CITY OF MERCER ISLAND

Pre-Application Meeting (PRE22-043)

Site Location:	3024 69 th Ave SE	Parcel Number	217510-0315
Lot Size:	8650 square feet	Zoning:	R-8.4 (Single Family)
Brief Project Description:	A proposal to construct a new single-family dwelling on a vacant lot.	Documents Provided:	1. Pre-Application Meeting Request Form 2. List of Questions 3. Site Plan 4. Geotechnical Evaluation 5. Tree Inventory & Replacement Submittal Information
Applicant Information:			
Name:	Clayton Herbst	Email:	clayton@shedbuilt.com
Phone:			708-567-9476
Second Pre-application Meeting Required:	Recommended	Another pre-application meeting is recommended closer to development when you have a better idea of what the project will look like.

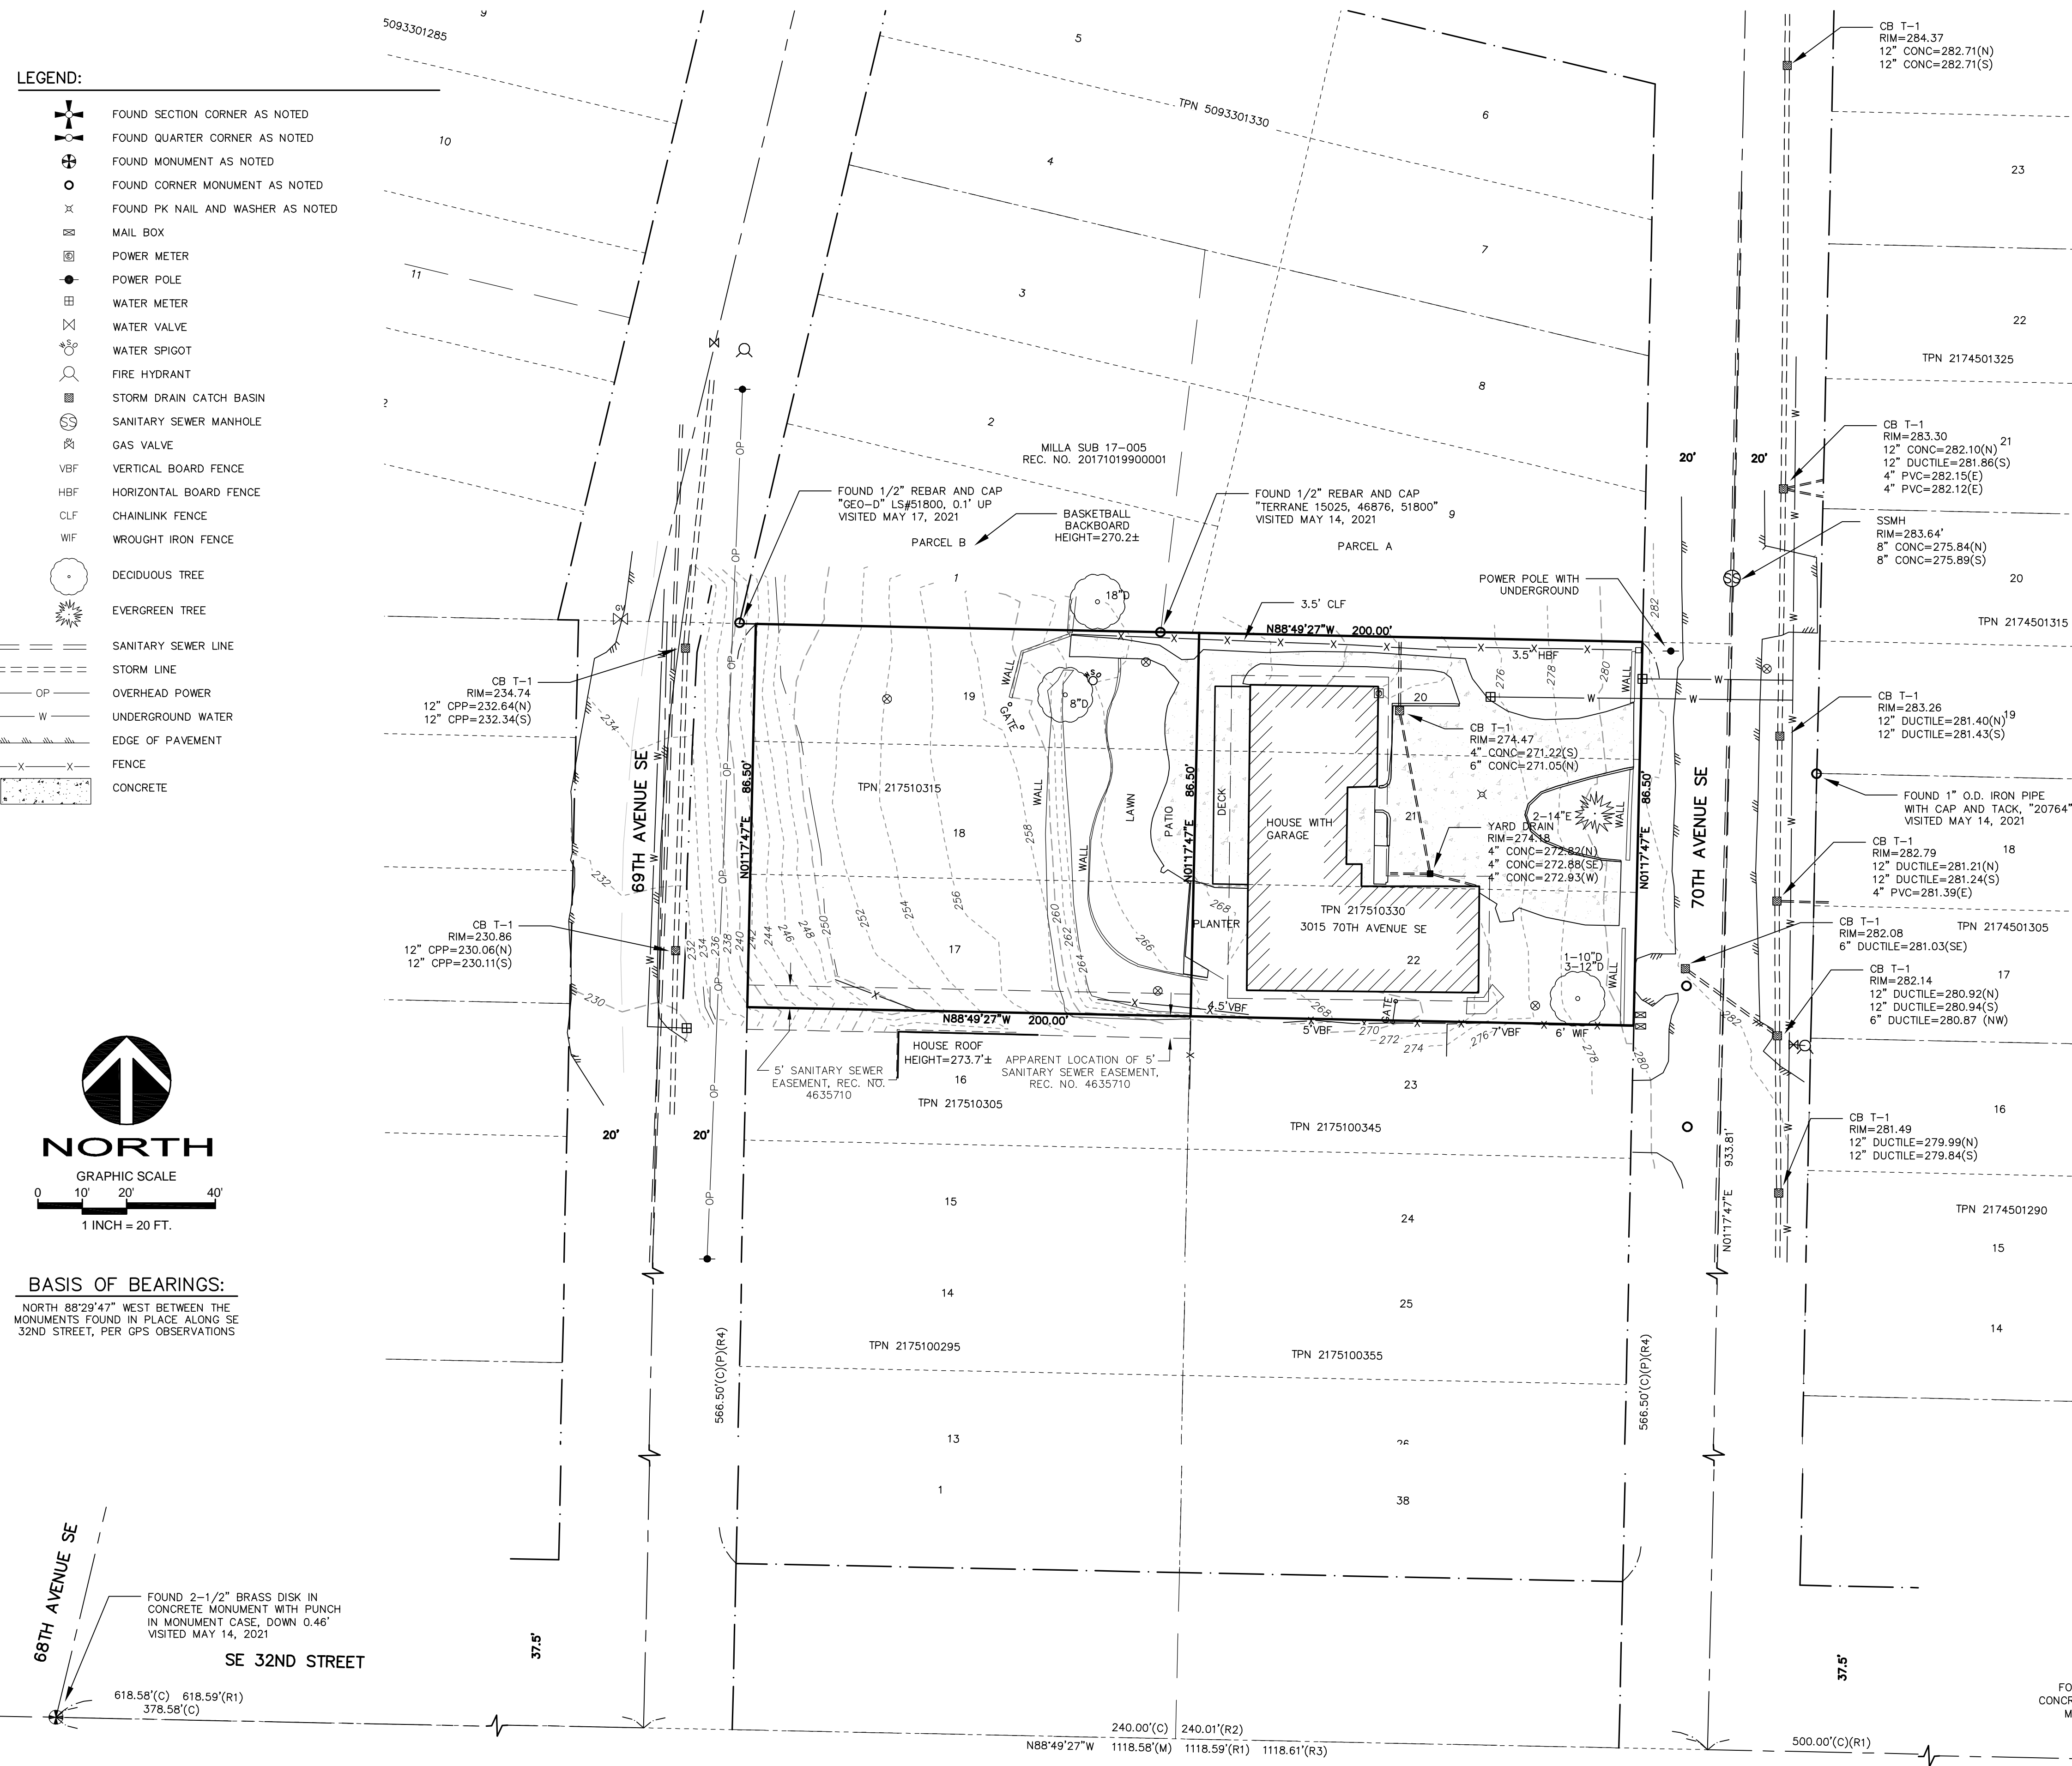
1. The lot is larger than 6000 square feet so variable side yard setbacks are needed. Please confirm that the setbacks shown on the site plan are correct.

Staff Response: The locations of the setbacks shown on the provided site plan are in the correct location. Any construction on this site is subject to the variable side yard setback provision of MICC 19.02.020(C)(1)(c)(iii). This provision is triggered when the wall façade abutting an interior side property line is 15 feet high or taller. It appears that at least 10 feet is provided on both sides of the house, which meets the largest potential variable side yard setback required by MICC 19.02.020(C)(1)(c)(iii).

DRAWING TITLE
EXTERIOR ELEVATIONS

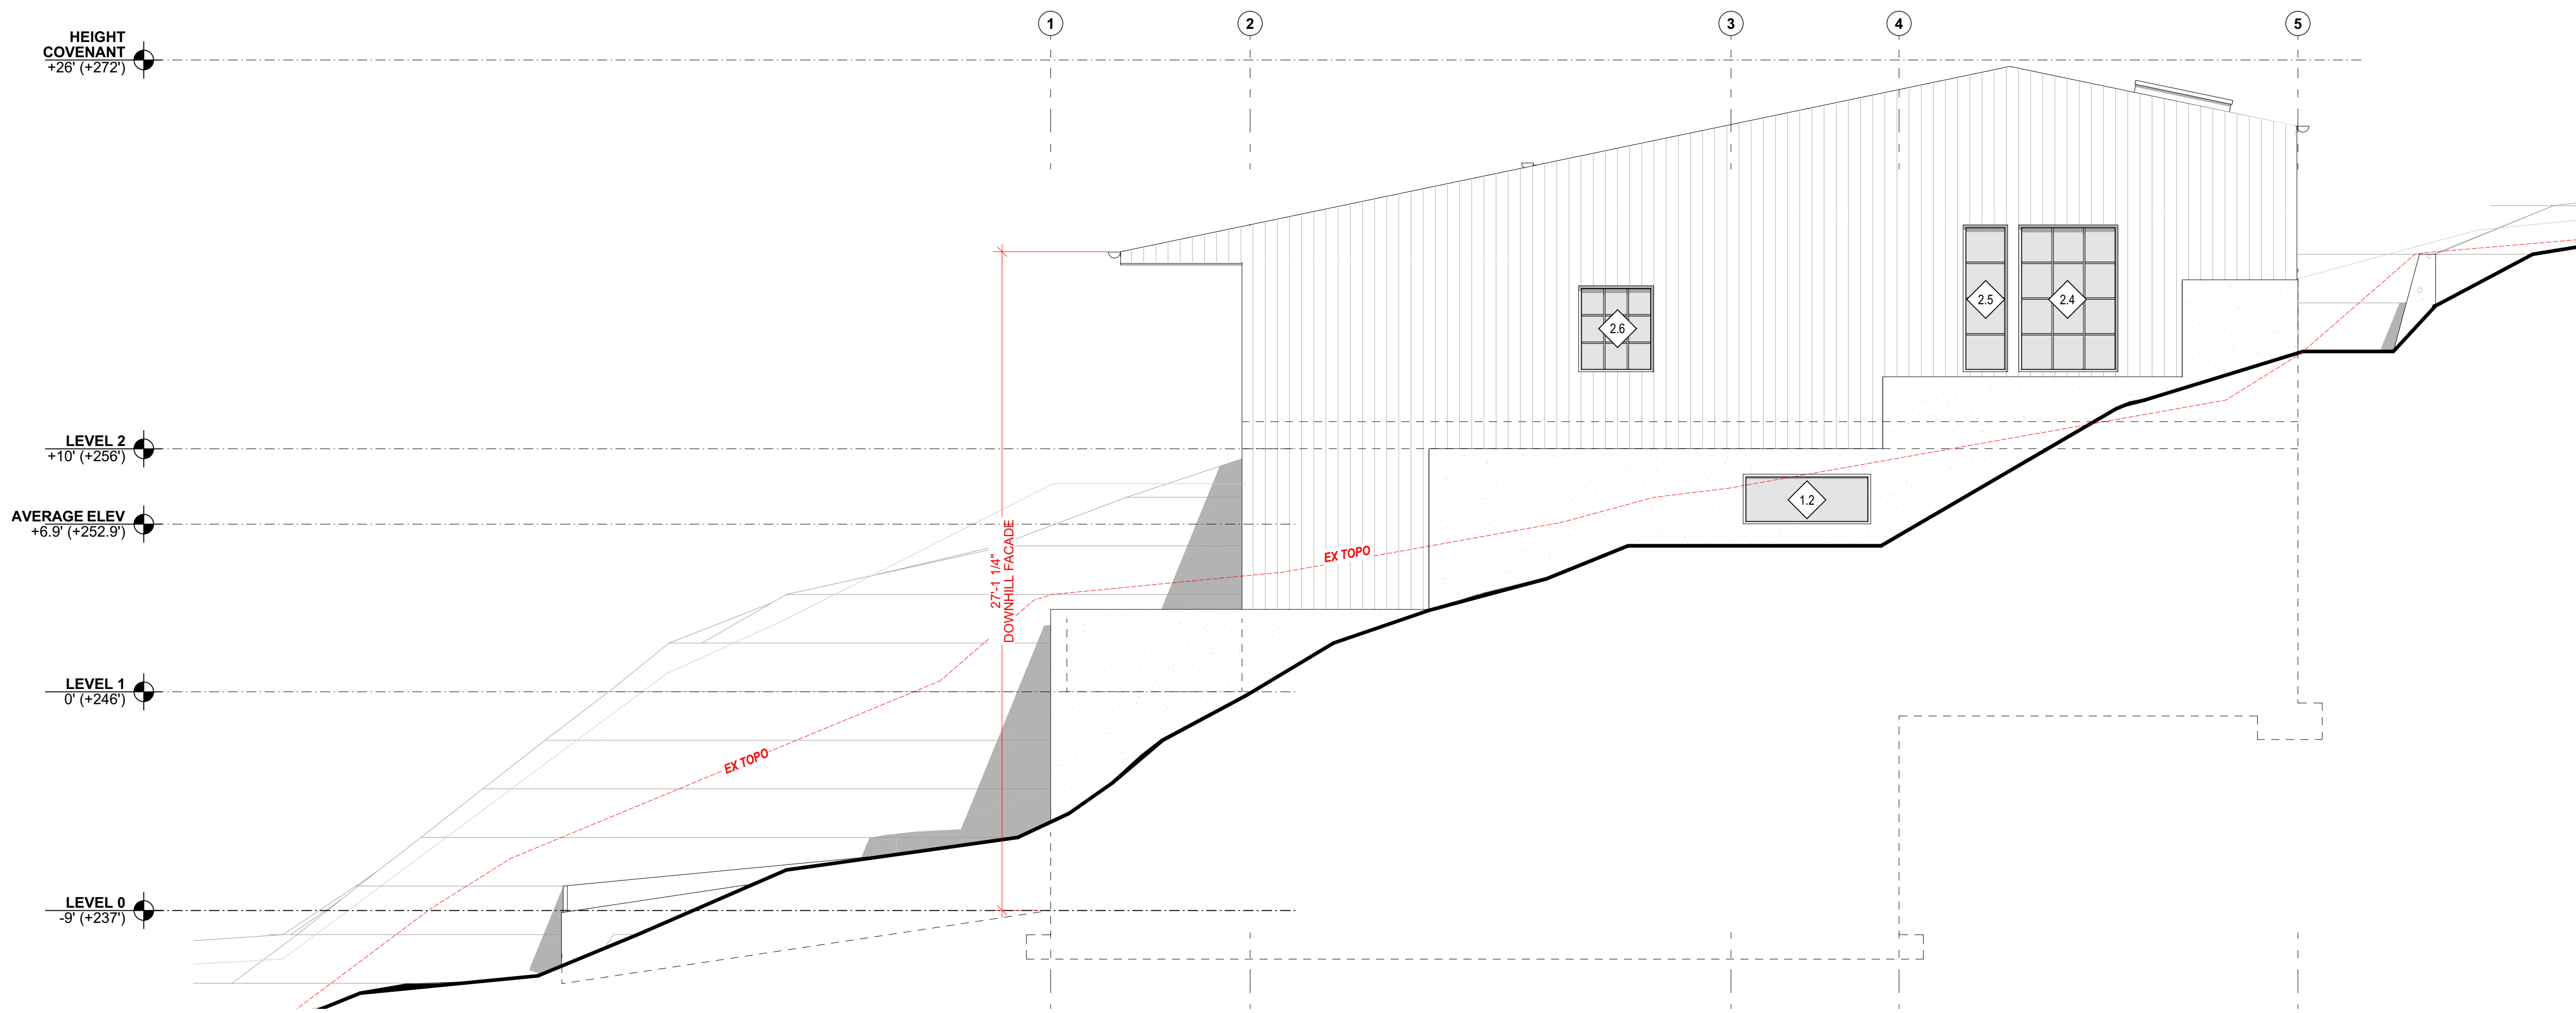
4. Please confirm how a stepped façade plays into the code language related to the furthest downhill extent of a building. Do sloped roofs affect the downhill building façade height?

Staff Response: MICC 19.02.020(E)(2) does not view a wall façade with a step back differently than a sheer wall façade with no step back. The wall downhill façade height for the proposed house would be measured from the top of Level 2 as depicted on sheet A-301 of the plans to the lower of existing or finished grade at the Garage level.

Since the downhill façade height is measured from the top of the wall, the style of the roof does not affect how the downhill façade height is measured.
